**Section 96A of the Town & Country Planning Act 1990 (as amended)
Town and Country Planning (Development Management Procedure) (England) Order 2015
(as amended) - Article 10**

Non-material amendment following the grant of AB/115/20/HH for the addition of a roof light to the stairwell.

1 Town Hall Yard Maltravers Street Arundel BN18 9AP

- Proposed Floor Plans and Elevations Dwg No 203106/02 Rev A

Drawing Name
**Floor Plans and Elevations -
Proposed**

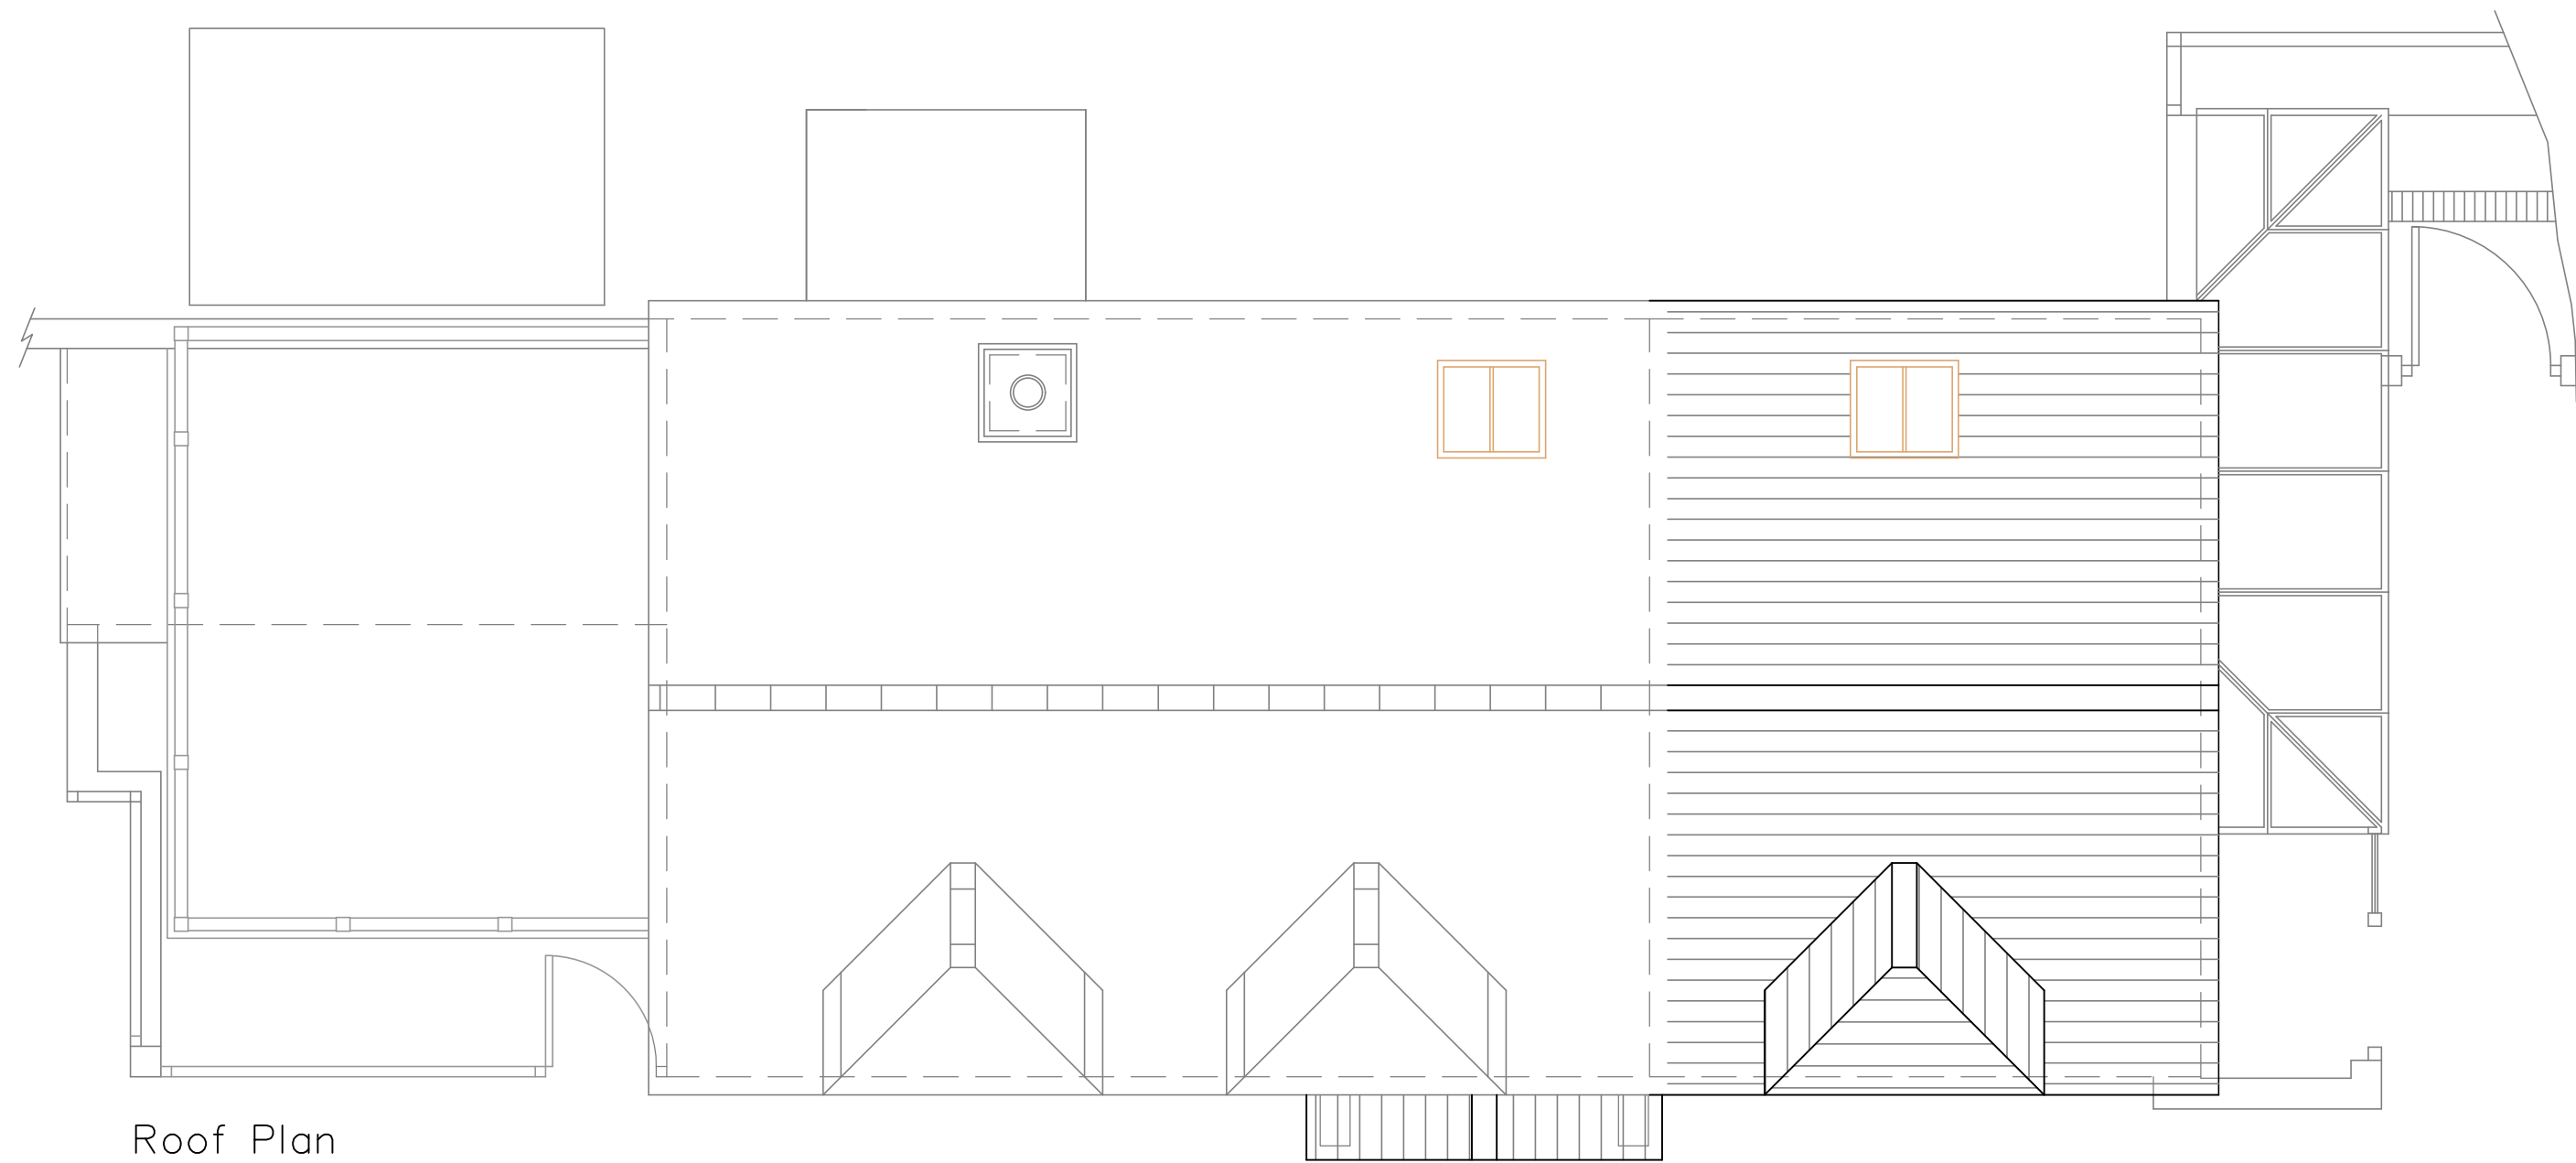
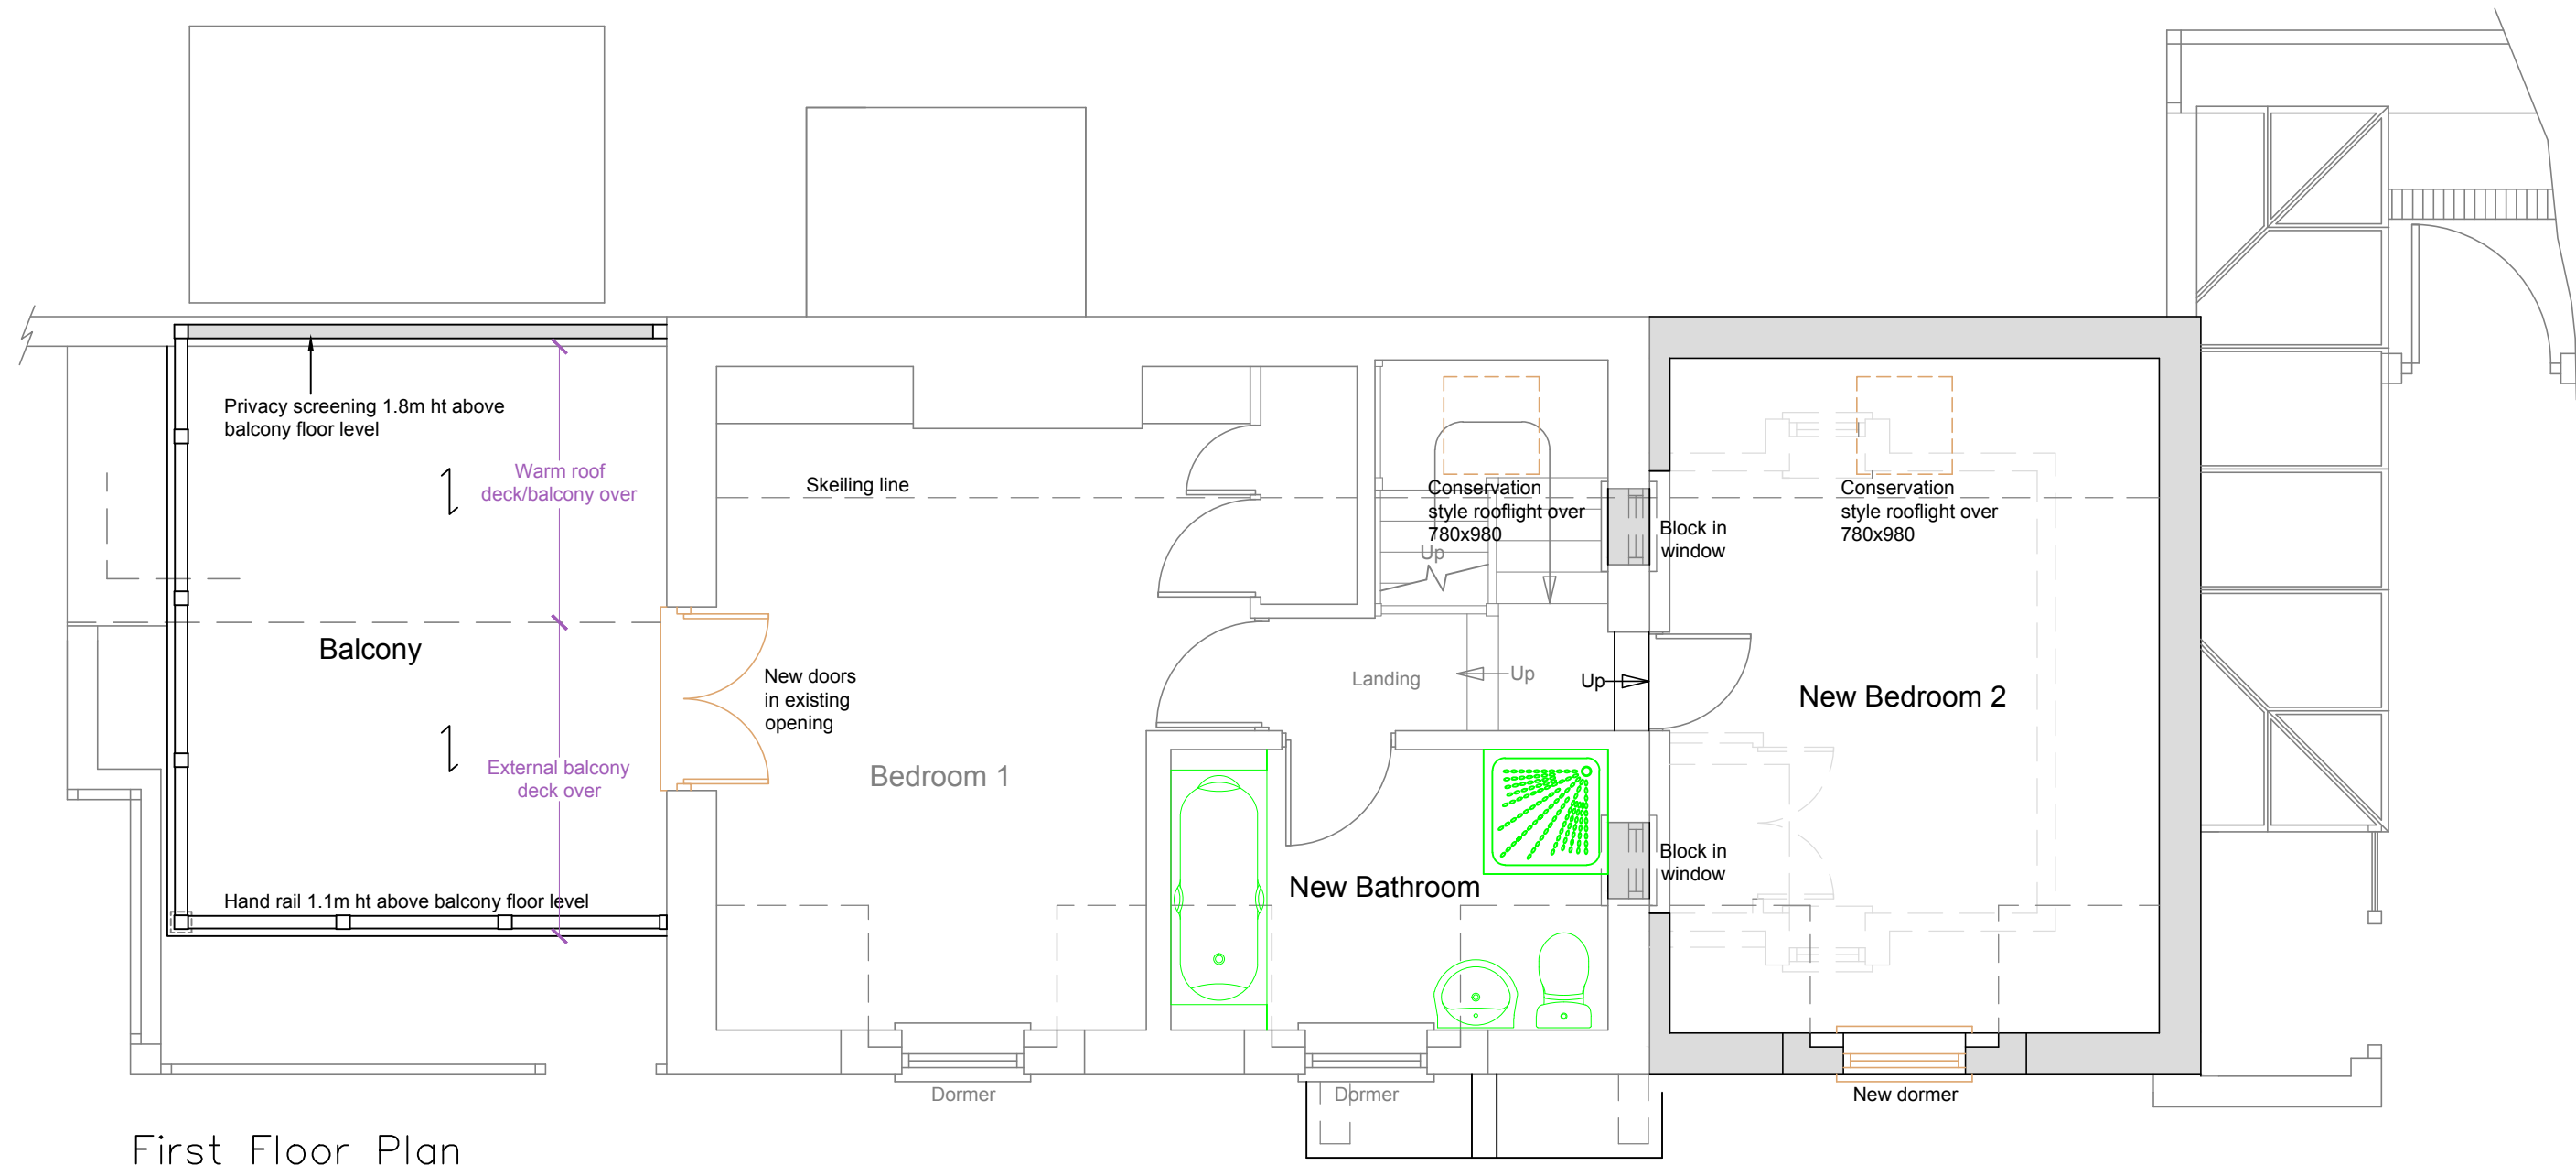
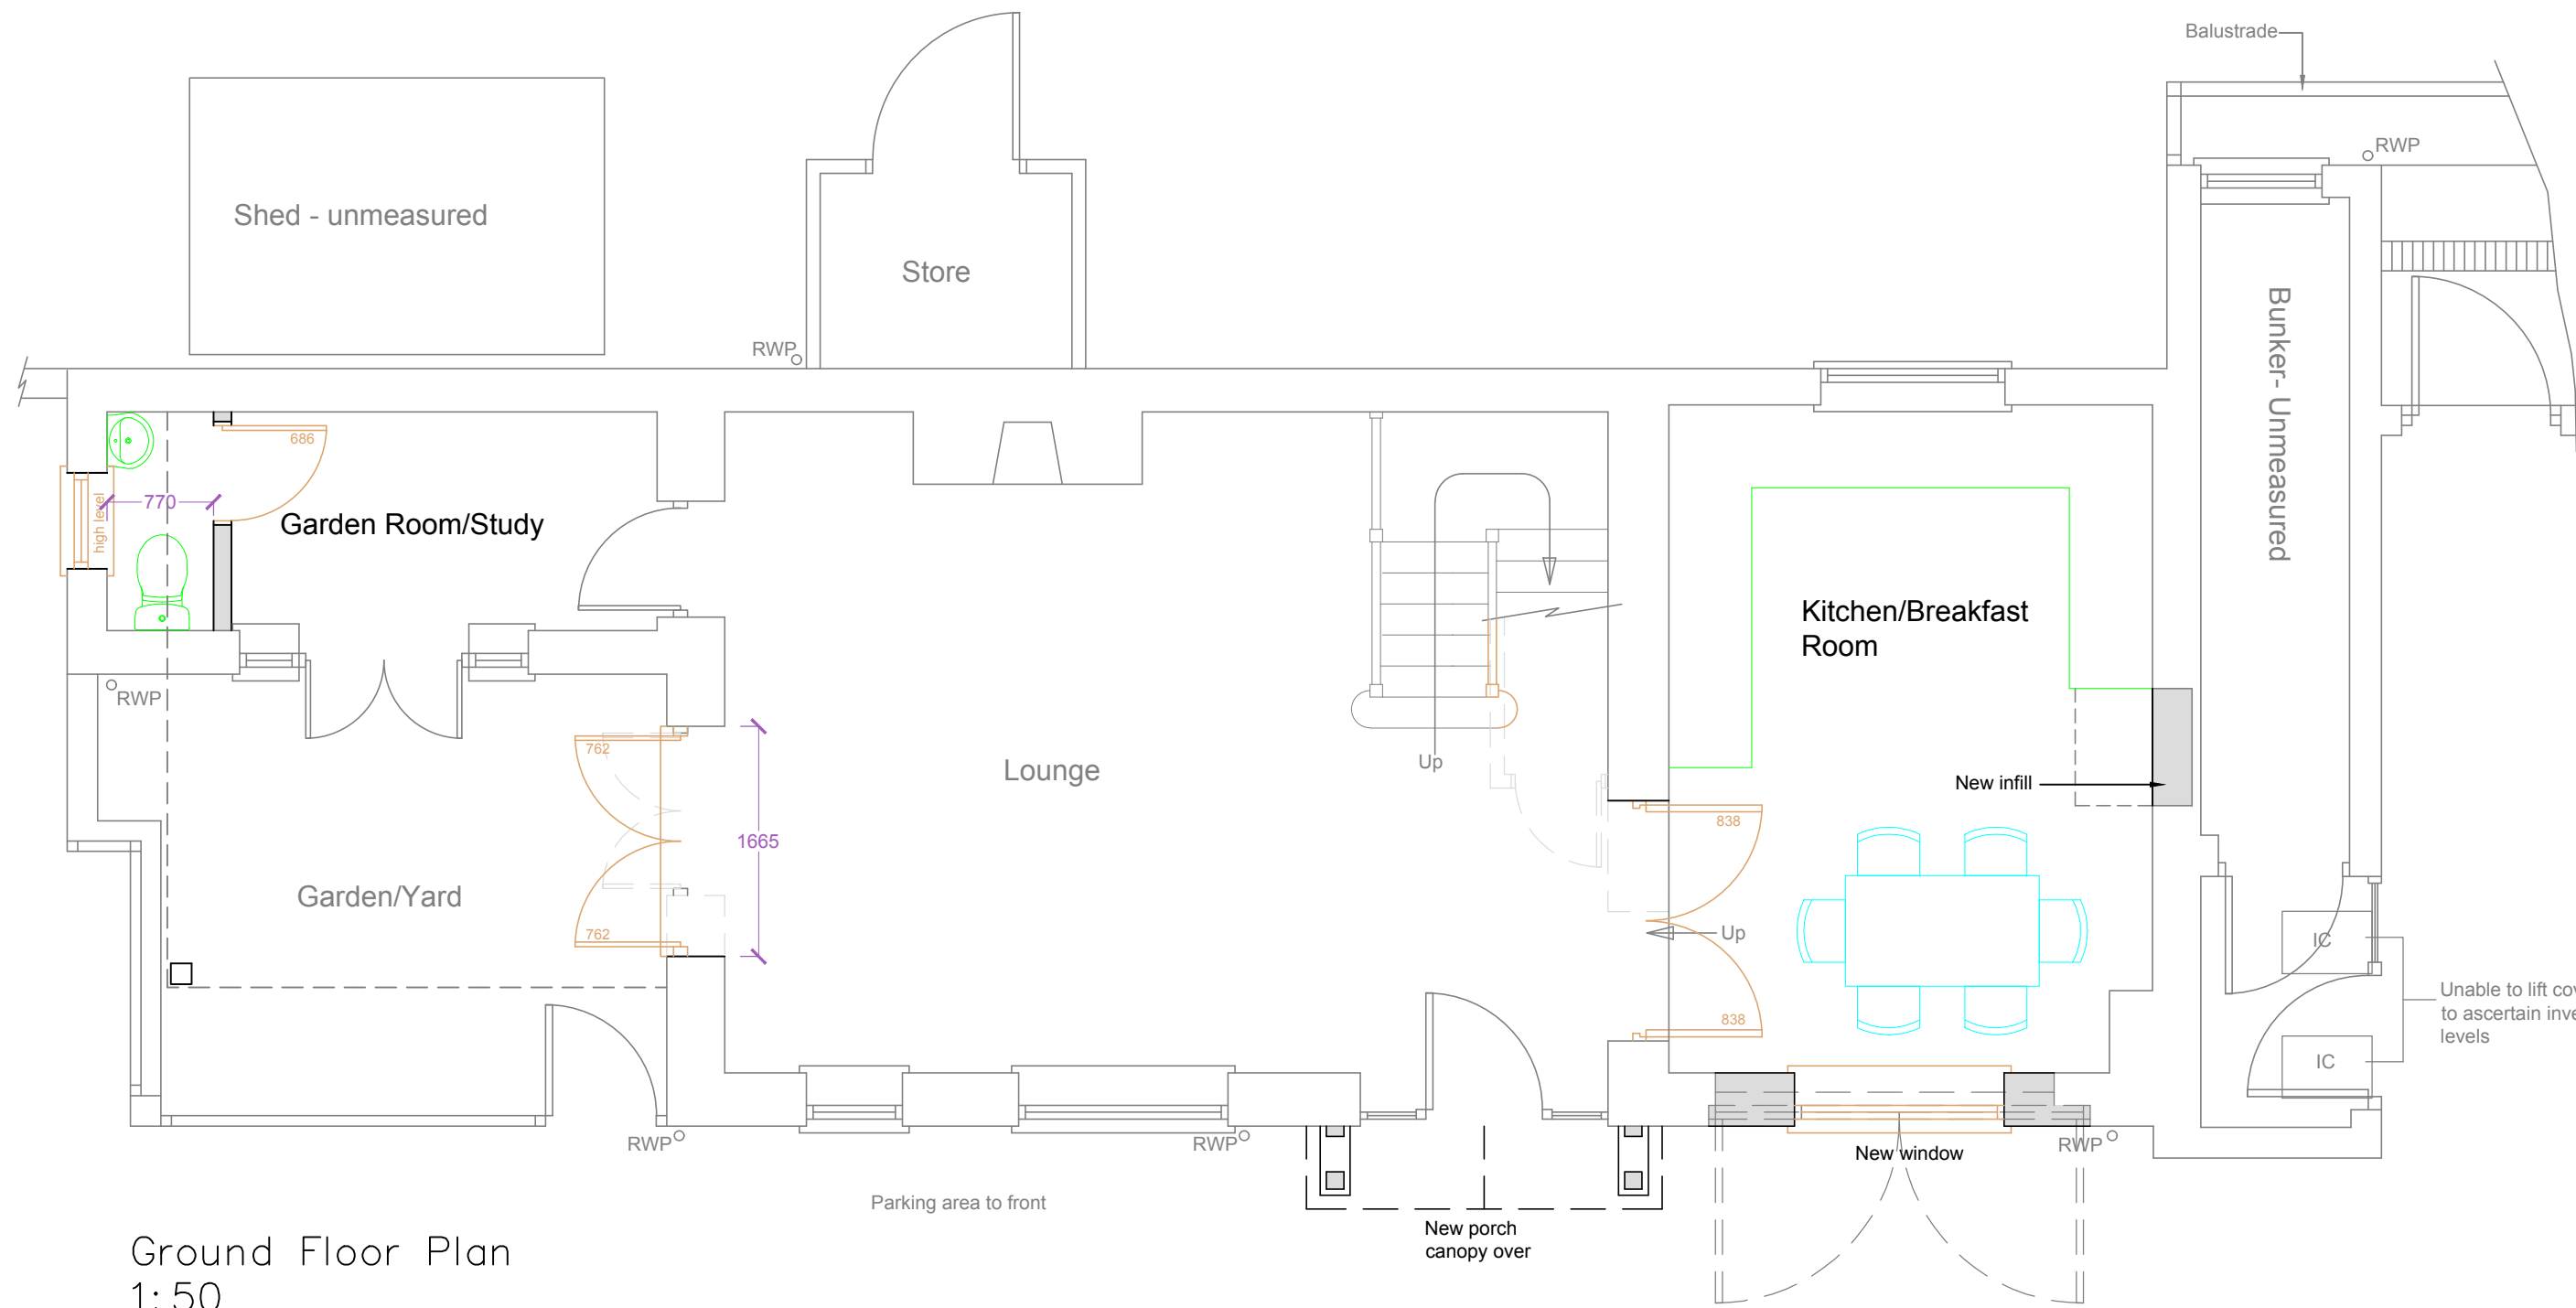
The reasons that this proposal has been accepted as Non-Material Amendments is because it does not materially alter the appearance of the building and gives no rise to adverse impacts by way of overlooking. It can therefore be considered under section 96A of the Town and Country Planning Act 1990.
